LCJ Mountain Farms Ltd – Comments on the Applicant’s Deadline 2 Submissions

Project: Beacon Fen Energy Park DCO (EN010151)

Deadline: D3 — 31 October 2025

Interested Party: LCJ Mountain Farms Ltd (IP Ref: F8D0BCE95)

Figure 4.1 Cumulative Development: Nationally Significant Infrastructure Projects

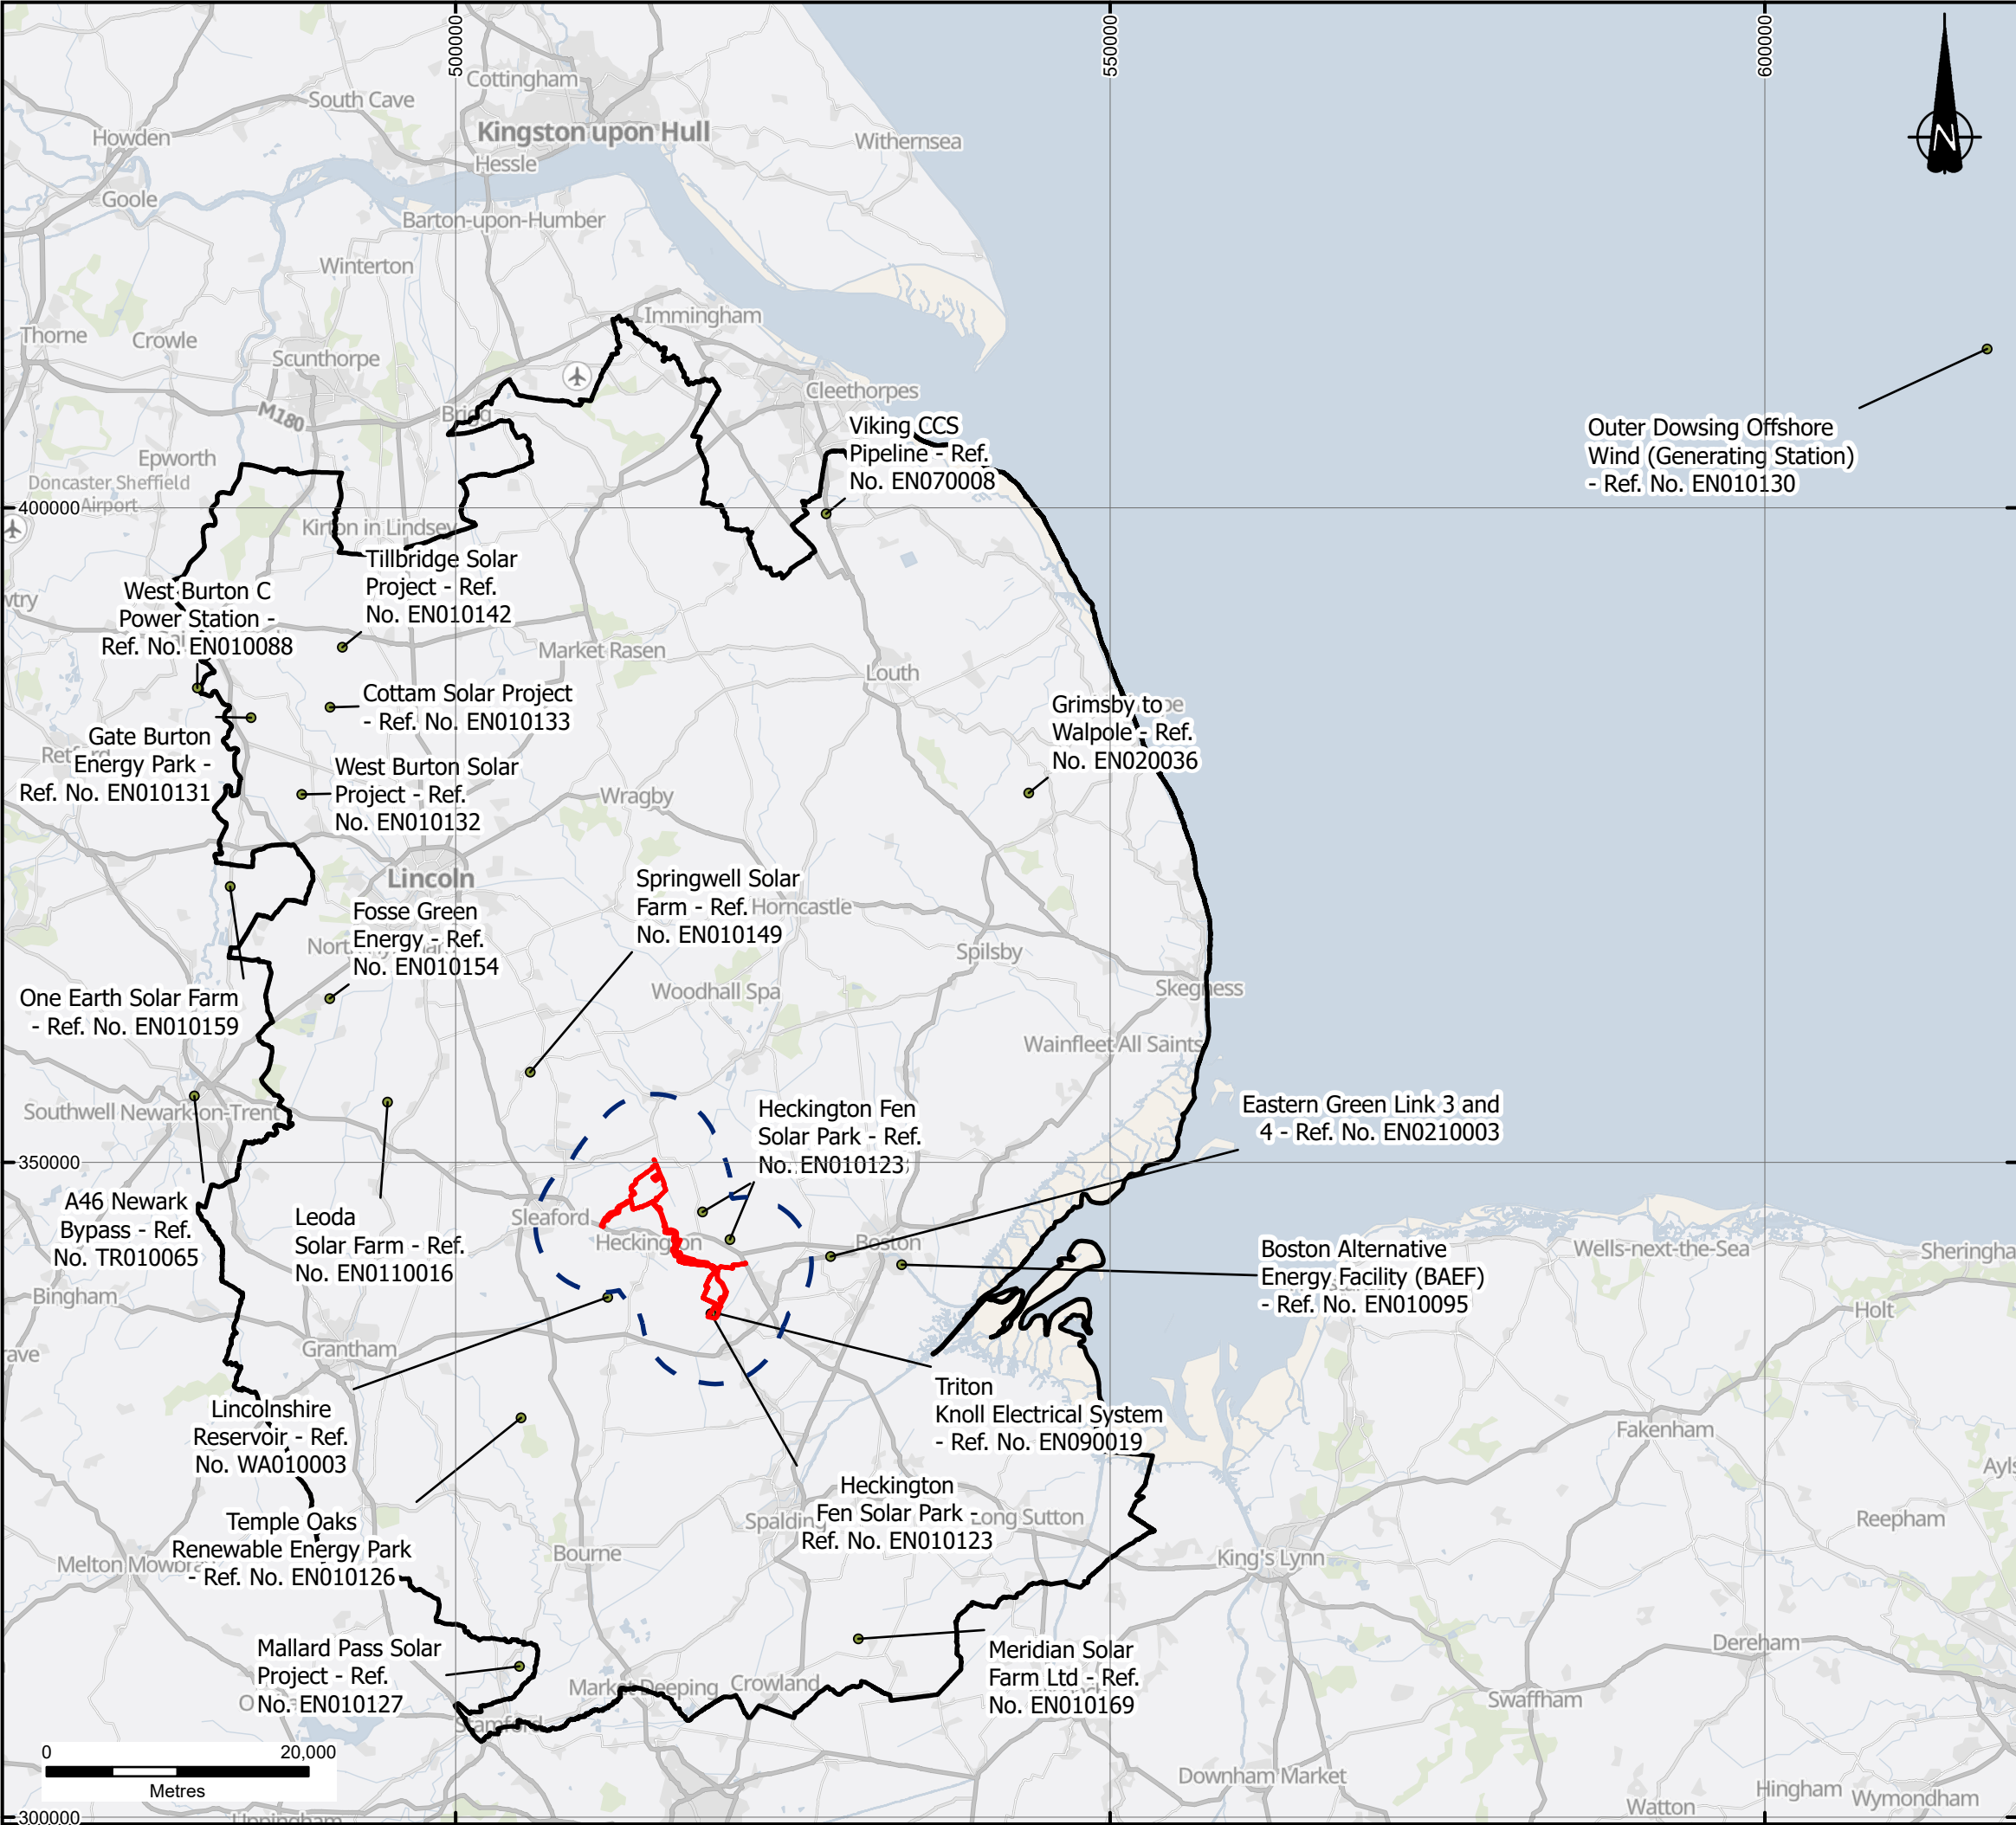
Applicant D2 doc (EL ID)	Issue	LCJMF comment	Consequence / Ask
		<p>Ex38) → a temporal cumulative on the same receptors;</p> <p>(iii) EIA duty — even if VL is baseline, the ES must still evaluate likely significant cumulative effects where residual effects persist. What’s missing: no quantified “greenfield vs repeat-use” comparison for the LWS 4722 / Old Forty Foot Drain corridor: HGV trips & stone tonnage relative to VL (4,800 t); soil structure/bulk density & recovery window; hydrological pathways (drain crossings/dewatering/interception); LWS length/area under repeat haul/compound; residual VL impacts elevating sensitivity.</p>	<p>additional disturbance must be assessed; a short addendum closes the gap without affecting CNP timelines.</p>
— 4.3 Regional cumulatives —			
<p>APP-069 (ES Ch.18 Cumulative Effects), REP1-029; Table 18.3</p>	<p><i>Applicant narrative (kept): Cumulative assessment provided, including with Heckington Fen Solar NSIP (consented Jan-2025); Table 18.3 summarises inter-cumulative effects.</i></p>	<p>High-level summary ≠ decision-grade cumulative for adjacent NSIPs. APP-069/Table 18.3 are largely narrative, lacking receptor-specific, quantified analysis for two near-contemporary, neighbouring NSIPs.</p> <p>What’s missing (illustratively):</p> <p>(i) Agricultural land/soils: no combined ALC/BMV tally, no cumulative soil structure/compaction risk where haul routes/compounds/reinstatements coincide or adjoin.</p> <p>(ii) Traffic/haulage: no integrated construction programme, daily/peak HGV totals, junction stress tests, or diversion sensitivity for phasing slips.</p>	<p>Rule 17, proportionate addendum (programme-neutral): 1) Provide quantified cumulative matrices (construction & operation) for soils/ALC loss, traffic (AADT/HGV, peak-hour), LVIA (paired viewpoints incl. night lighting), ecology (LWS length/area; crossings), PRoW/community receptors. 2) Map overlapping/adjacent compounds, haul roads, access nodes; include a combined construction schedule identifying concurrency. 3) Commit to co-ordinated mitigation with Heckington Fen: stagger peak HGVs, relocate/resize compounds to avoid LWS/PRoW pinch-points, right-angle LWS crossings only, shared reinstatement specs, joint community liaison. 4) File a short Statement of Common Methodology with Heckington Fen to close scope gaps left by Table 18.3. Outcome: a decision-grade cumulative picture consistent with EN-1 proportionality—documentation, not redesign.</p>

ENVIRONMENT AGENCY DEPTH OF  
SURFACE WATER FLOODING  
(CLIMATE CHANGE SCENARIO 2040 - 2060)  
SHEET 3 OF 4

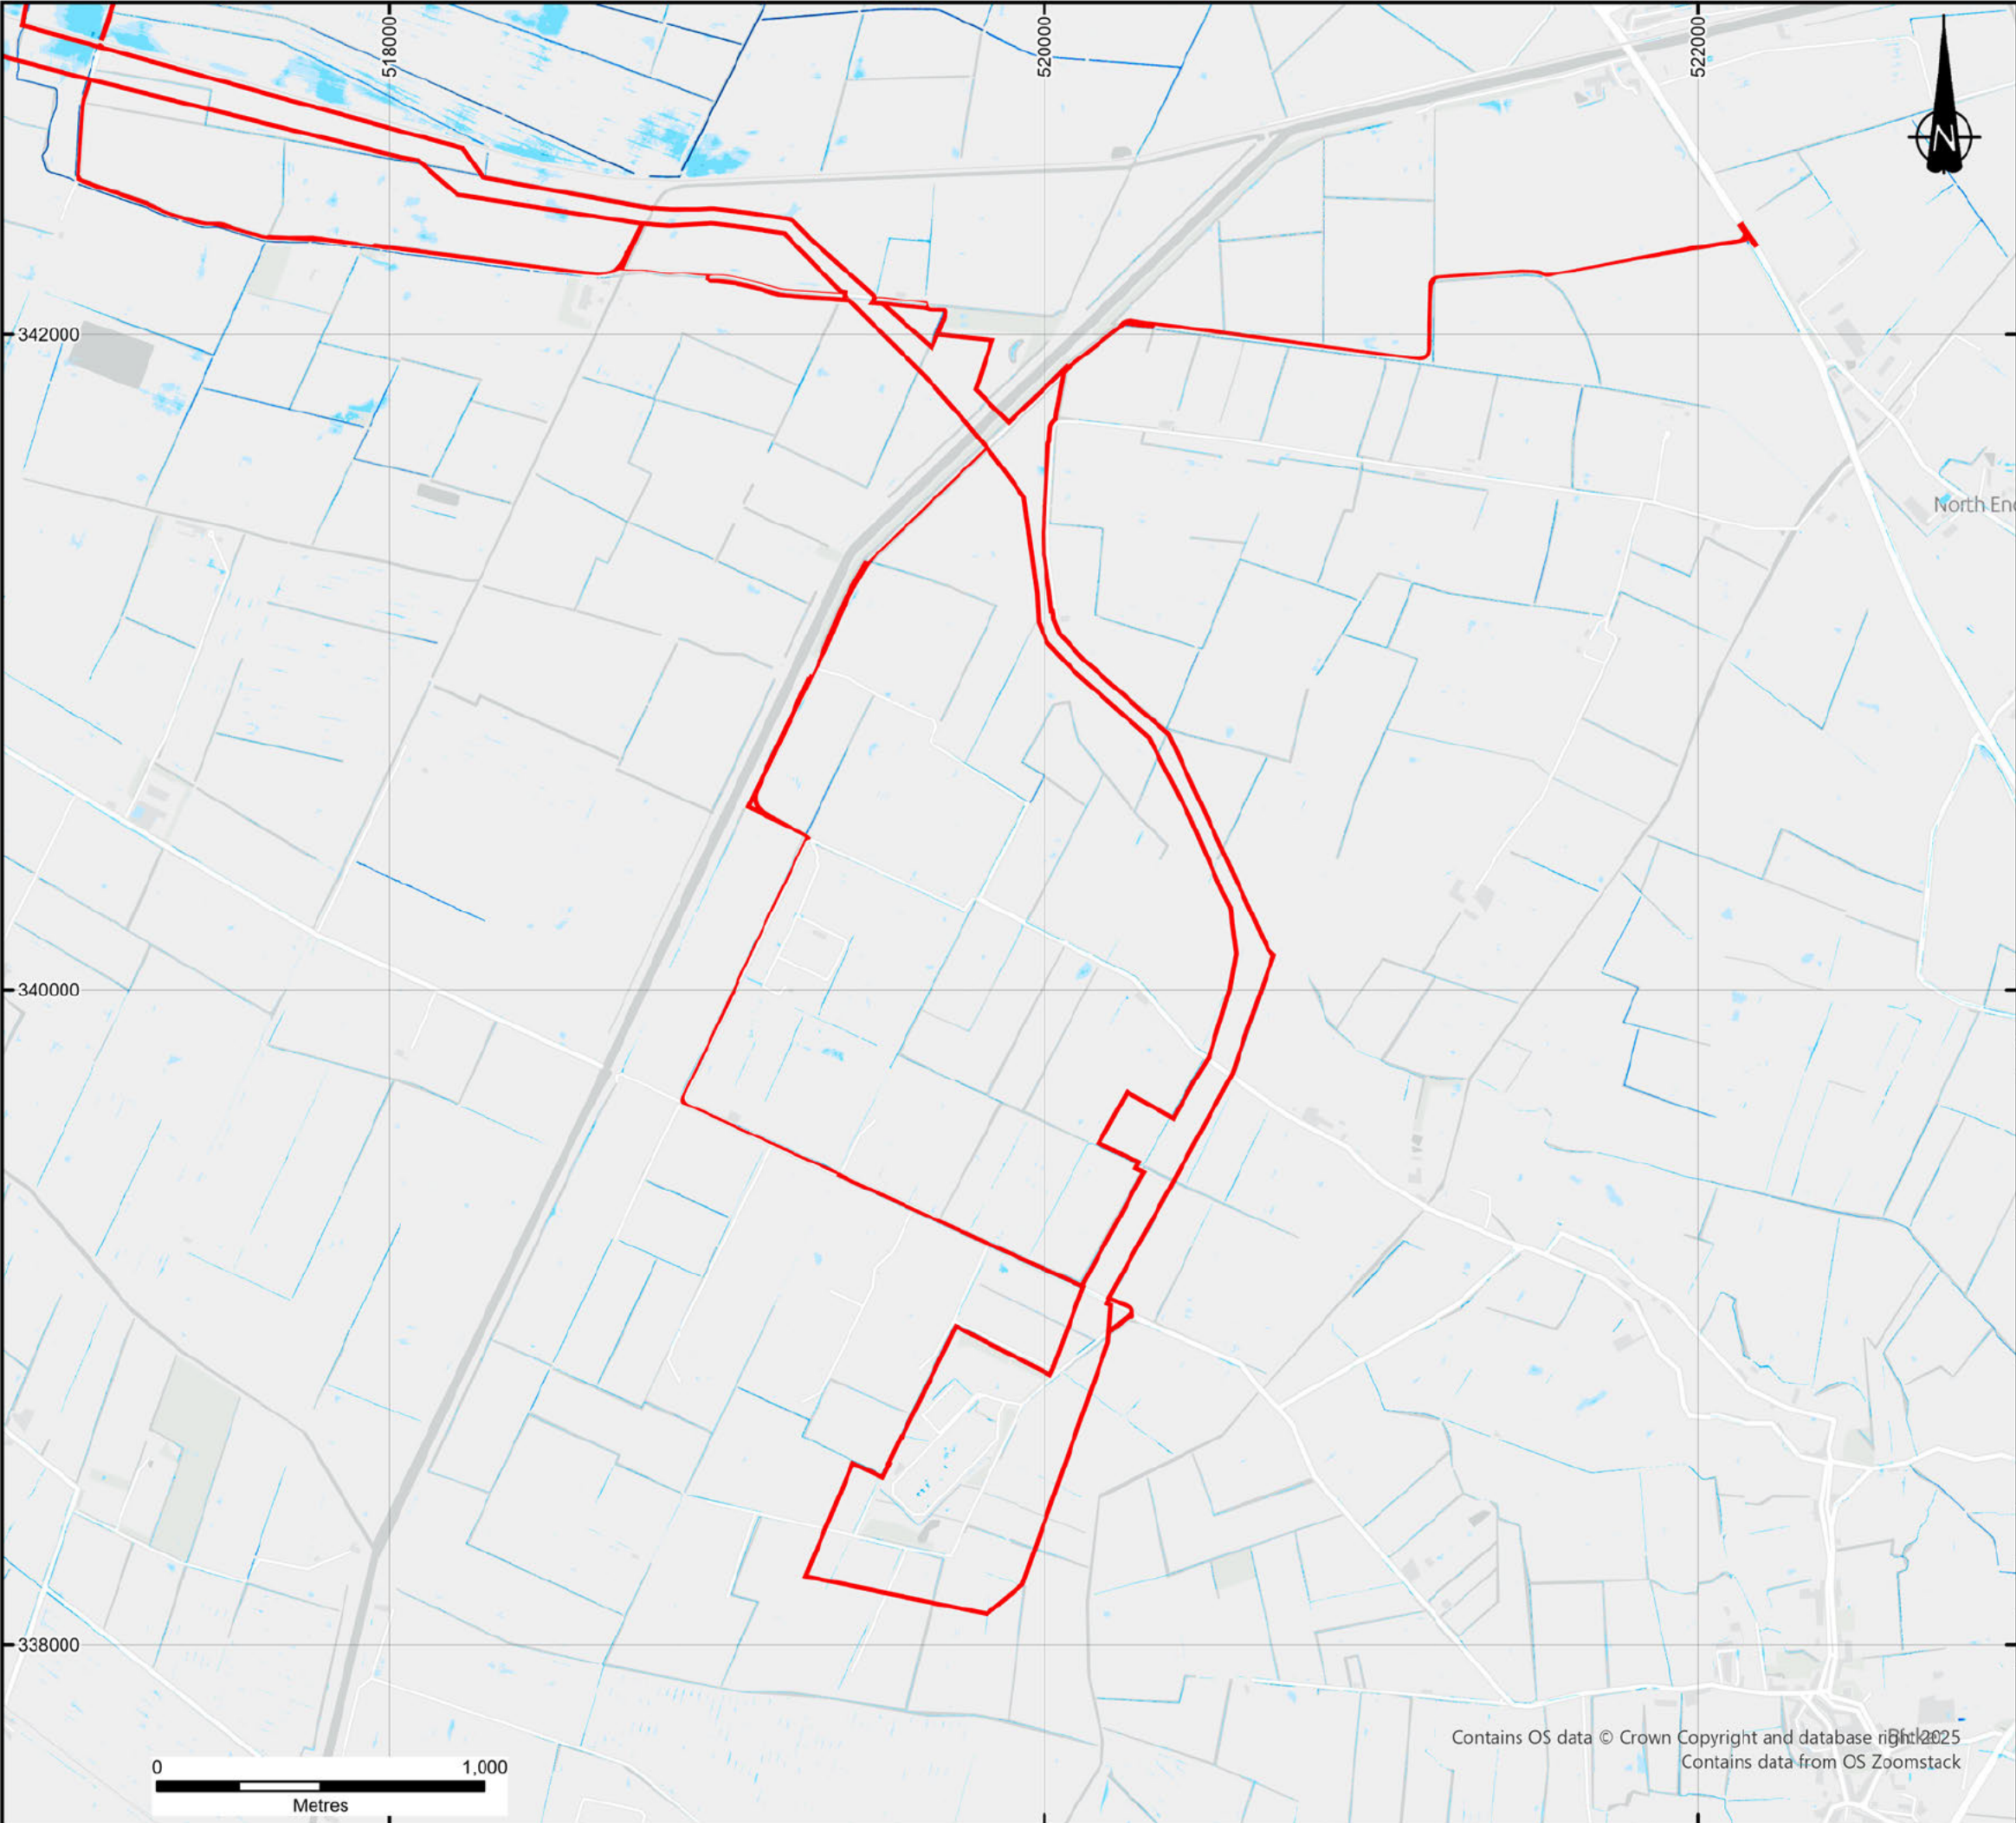
— 3.15 Flood risk baseline materially worsened (NaFRA2 2025) —			
AS-022 (Climate Change Allowances & NaFRA2 Review); Doc 9.6 (Responses to ExQ1 WFR.1.1)	<i>Applicant narrative (kept): NaFRA2 became available mid-2025 after site selection; implications are addressed in AS-022; scheme aligns with latest flood-risk guidance (see Doc 9.6).</i>	<p>Timing isn’t a get-out; decisions use the current baseline.</p> <p>Under EN-1 (2023) the ExA/SoS determine on the latest evidence. NaFRA2 (Jan–Mar 2025) materially increases surface-water extents over the chosen layout (Ref E / Doc 9.1). AS-022 considers mitigation</p>	<p>Direction sought (programme-neutral): require a one-page NaFRA2-based addendum:</p> <p>Table A – Sequential parity: Chosen BESS vs LCJMF FZ1 BESS, reporting FZ 1/2/3 exposure, NaFRA2 depth/extent, residual risk post-mitigation.</p>

Applicant D2 doc (EL ID)	Issue	LCJMF comment	Consequence / Ask
		<p>for the selected scheme but does not re-apply the Sequential/Exception Tests against LCJMF's BESS-in-FZ1 partial alternative (Ex22) with nearby ALC 3a/3b PV (~2.7 km to PoC).</p> <p>The Sequential Test isn't "mitigate only"; it first asks if a less vulnerable configuration exists meeting objectives.</p> <p>Consultation record: LCJMF's 21 Dec 2023 letter (Ex25) set seven routing/capacity/BESS queries; 23 Jan 2024 reply (Ex26) deferred to generic PEIR text, providing no site-specific, quantified appraisal. With NaFRA2 now in play, the omission is amplified.</p>	<p>Table B – Delivery parity: objective fit, cable length deltas (~2.7 km proximity), LWS 4722 interaction, indicative logistics (HGV/stone where already calculated).</p> <p>If the FZ1-BESS alternative scores better on flood risk without schedule harm, either:</p> <ul style="list-style-type: none"> (i) adopt future-proofing on LCJMF land now (33 kV duct + mapped spur-node / Reserved Strip + HDD sleeves + pull-pits + as-builts + deemed-consent step-in), (ii) provide a reasoned engineering/safety basis for declining and propose an alternative safeguard, incl. a fallback sterilisation mechanism (easement + offsets + halos; indexed; incl. professional/management costs).
